Your Ref :
Our Ref : LU/144/18/NMA

Section 96A of the Town & Country Planning Act 1990 (as amended)
Town and Country Planning (Development Management Procedure) (England) Order 2015 (as amended) - Article 10

Non-material amendment following a grant of LU/340/17/HH to bring first floor extension front wall forward to line through with existing front elevation wall.
11 Granary Way, Littlehampton, ,

PLANS AS PROPOSED				 NORTH
Scale	1 : 100	@A3	drawn by	
Date	MAY 2018	checked	SM	
Drawing Number		0080 - 04		A

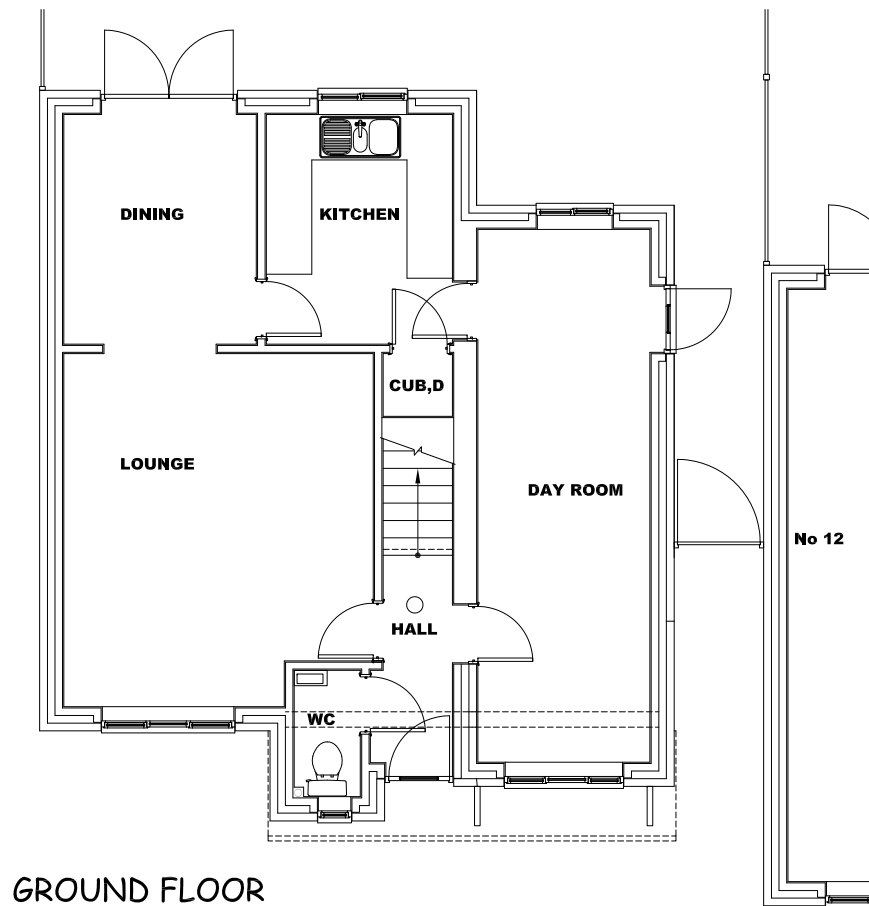
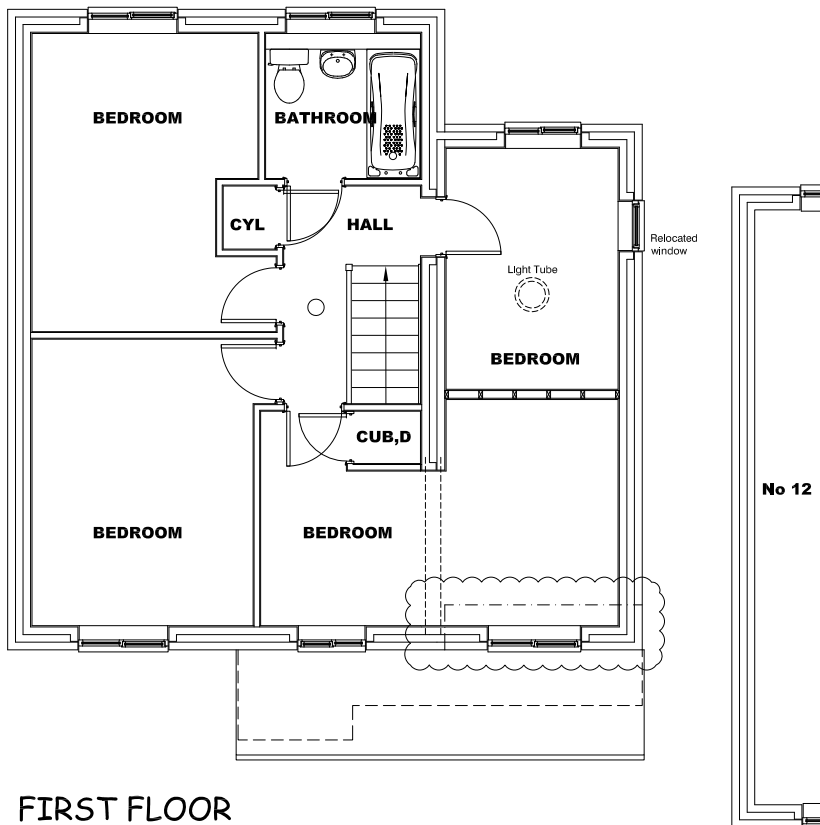
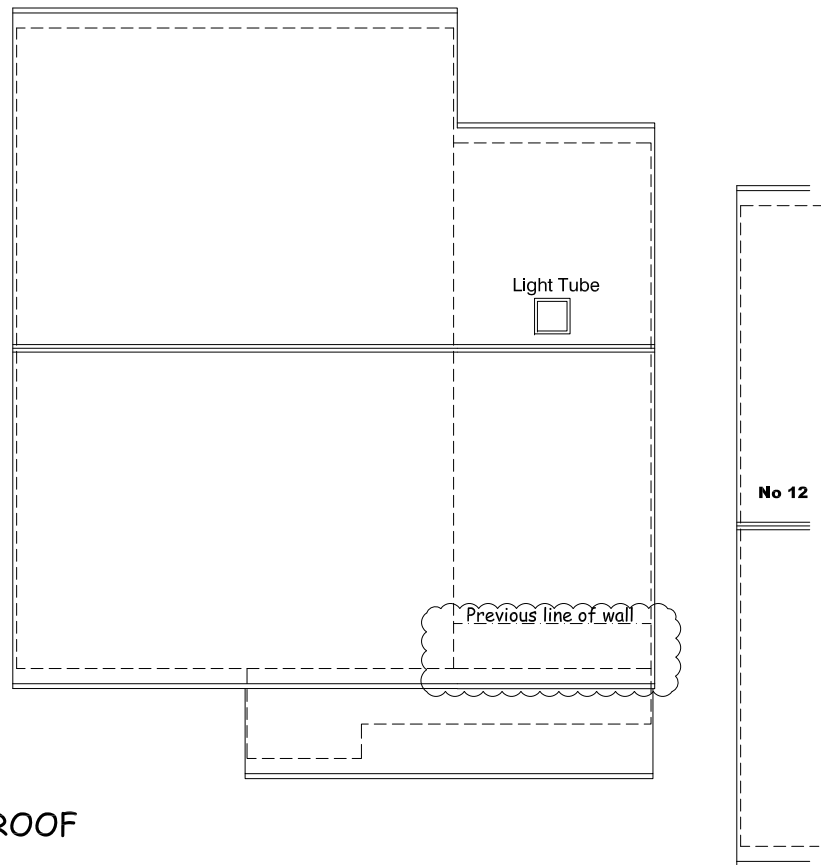
The reasons that these proposals have been accepted as Non-Material Amendments is because the extension at first floor will be enlarged by only 0.5m and the roof line and front elevation will project no further forward than the existing. As such the changes do not materially alter the planning permission and do not necessitate additional consultation with local residents. The changes can therefore be considered as an NMA to application LU/340/17/HH under section 96A of the Town and Country Planning Act 1990.
